**SSD-9671 – PROPOSED ADDITIONS TO YOUNG HIGH SCHOOL, CAMPBELL STREET, YOUNG.**

I refer to your correspondence regarding the subject application which was referred to Transport for NSW (TfNSW) for assessment and comment.

Figure 3 - Preliminary Construction Vehicle Routes

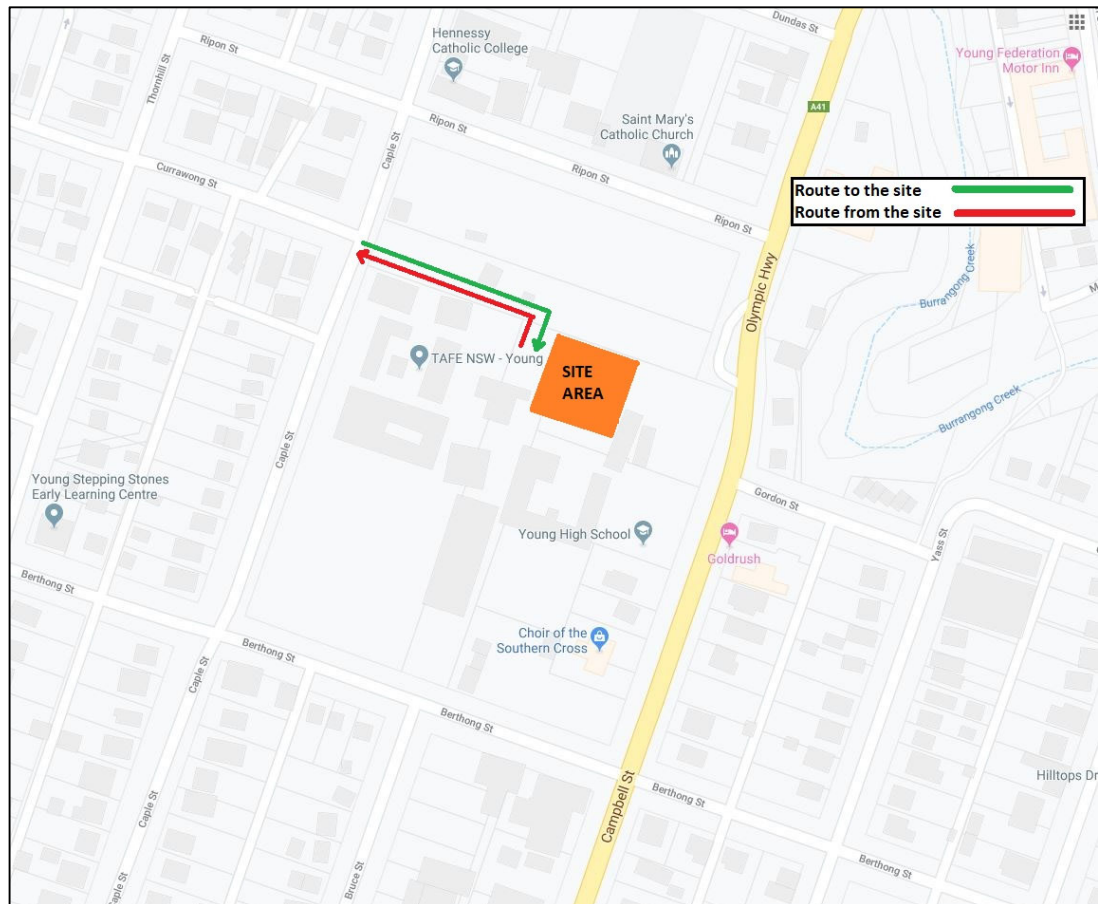
Section 5.6.5 (page 53) of the EIS indicates that pedestrian and cyclist infrastructure will remain open and mostly unaffected by construction activities. Appropriate measures should be implemented to ensure that pedestrian and cycling movements along footways and cycleways are maintained at all time during constructions activities. If the development requires closure of either facility, the Construction Management should detail adequate safety and diversion measures to be implemented to limit time delay and detour distances.
